Response to EIS Exhibition of Major Project SSD 8970, St Josephs College Sports Complex

Submitted by: Margaret C Stuart, Honorary Secretary, Residents Committee, Heritage of Hunters Hill, 35 Gladesville Road, Hunters Hill NSW 2110.

LANDSCAPE STRATEGY

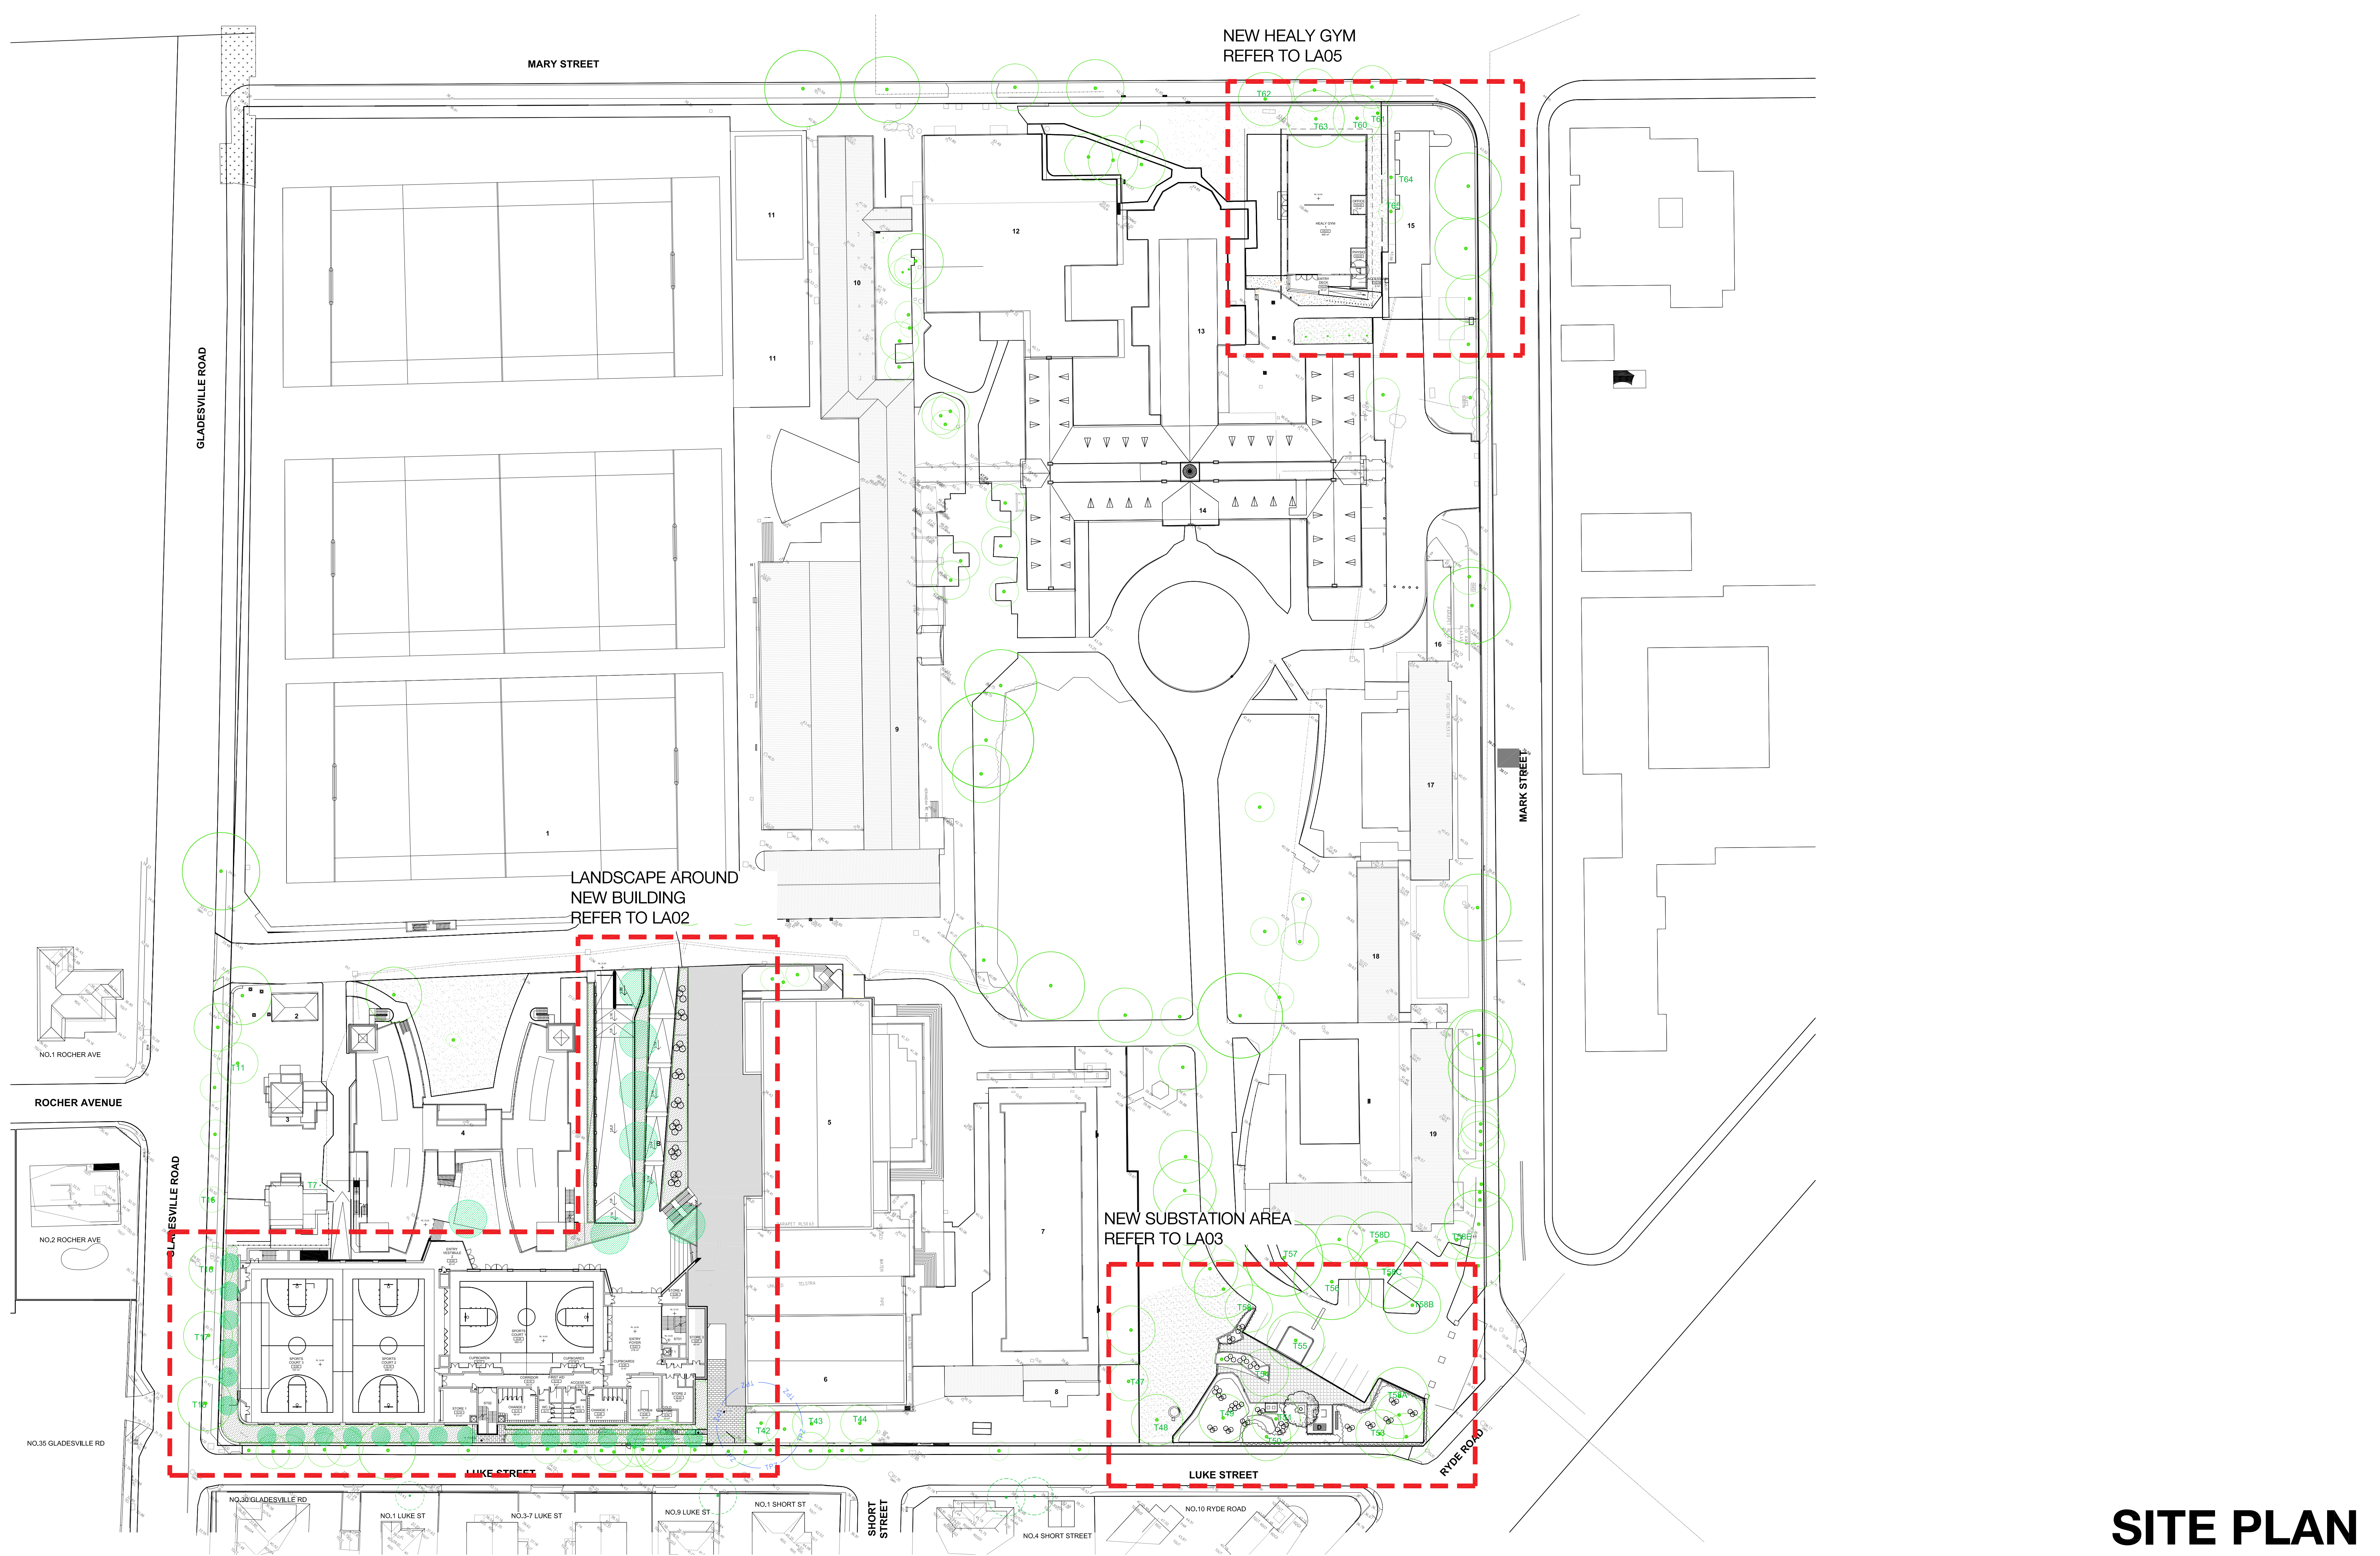
- Trees on Gladesville Road and Luke Street (Figure 13 and p.24)

It is stated on the Figure that 3 existing street trees on Gladesville Road will be trimmed to the site boundary. These healthy, mature trees have approx 30-50% of their canopy stretching over the stone wall into the College. Has the viability of these trees been considered following such drastic pruning?

It would seem from this same Figure that all vegetation including trees will be removed from the Luke Street verge adjacent to the building site. It will be years before the planned plantings of lemon scented myrtle could grow along this strip. This is an adverse outcome for the Heritage residents and the local amenity.
